Our Ref: 14683-HISC-EJE RtS2 (rev.1)
Date: 9 March 2026

RE: **Response to Submissions 2 (RtS2) – Hunter Indoor Sports Centre (SSD-65595459)**

This architectural statement supports the Response to Submissions 2 (RtS2) for State Significant Development Application (SSD- 65595459) for the proposed Hunter Indoor Sport Centre (HISC) at 2 Monash Road and 24 Wallarah Road, New Lambton.

| DRAWING | TITLE |
|------------------|--|
| 250106-DA-980-01 | SWEPT PATH PLAN - 14.5m BUS |

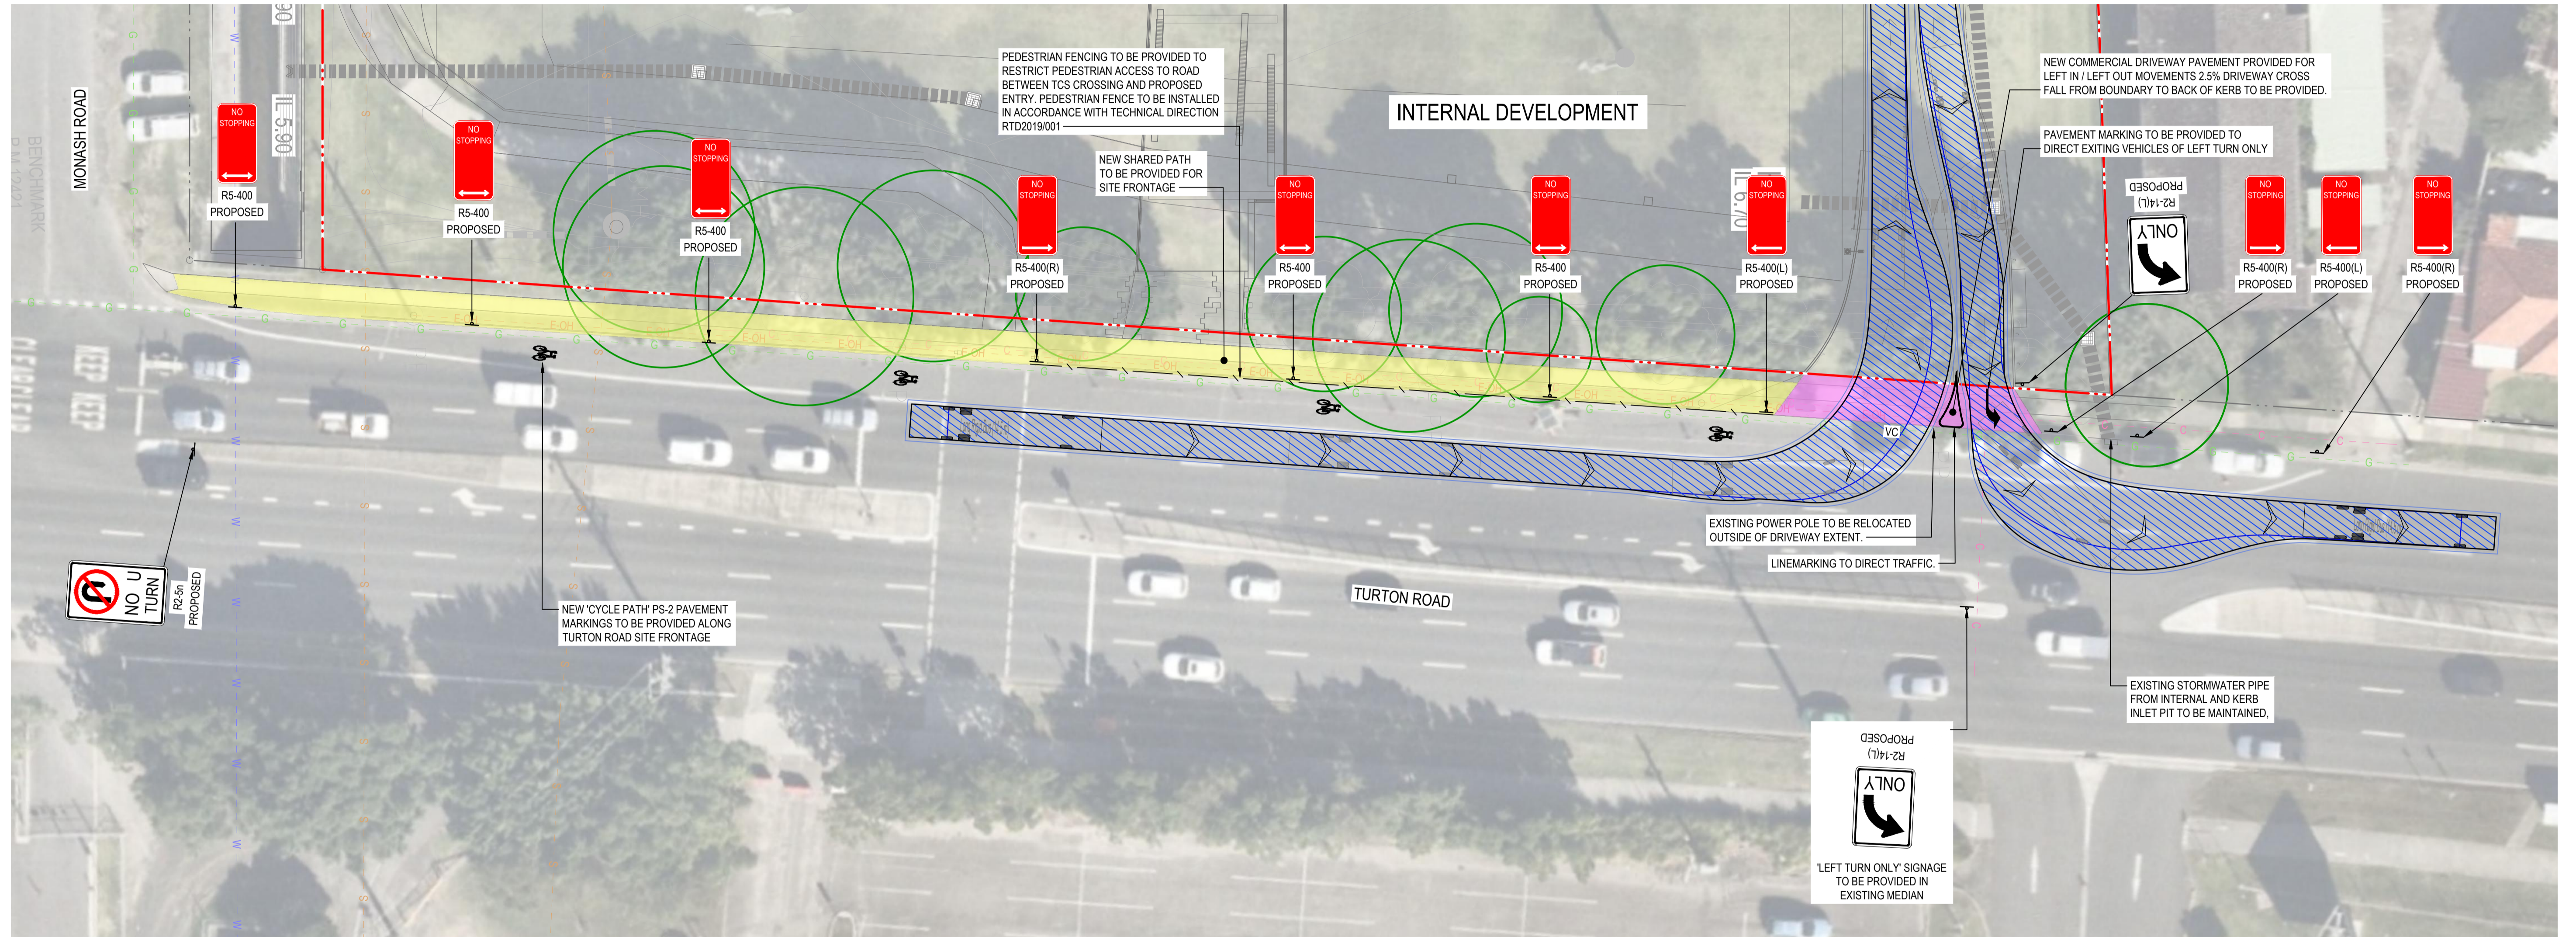
The swept paths for a 14.5m bus require traversing multiple lanes on Turton Road when entering and exiting the site. What is the impact on traffic queuing and safety both in the car park and on Turton Road?

It is also noted such buses result in potential vehicle conflict within the car park itself. It is recommended the layout be revised to address this concern.

The swept paths shown by Groundswell (refer to drwg DA-980-01, & part screenshot/Fig.3 below), demonstrate that a 14.5m long rigid bus, turns entirely from the kerb side lane of the two north bound lanes, when entering the site. Given there is adequate parking provided within the site and adequate queuing distance prior to reaching the parking zone, it is not considered there will be any safety issues within the carpark or Turton Road.

When egressing from the site, the 14.5m long rigid bus utilises the pavement within Turton Road (i.e. both travel lanes). It is unclear why the bus would need to demonstrate turning into the kerb side lane of the two lanes only, as this would be an unsafe and illegal manoeuvre if there was a vehicle travelling north in the second lane. If the driveway was further widened to allow buses to turn into the kerb side lane only, then this would result in a poor outcome for pedestrians in the footpath, as it would increase the width of the driveway beyond the guidelines for pedestrian crossings.

Within the internal carpark area, swept paths demonstrate that a 14.5m long rigid bus can travel through the site, without impeding parking spots. Refer Groundswell drwg DA-980-01, & part screenshot/Fig.4 below.

The swept paths show the 14.5 long rigid bus overlapping a “no parking zone” at the building’s entrance (i.e. a hatched line-marking area only), but doesn’t overlap any of the Drop-Off spaces, or any other car spaces on site.
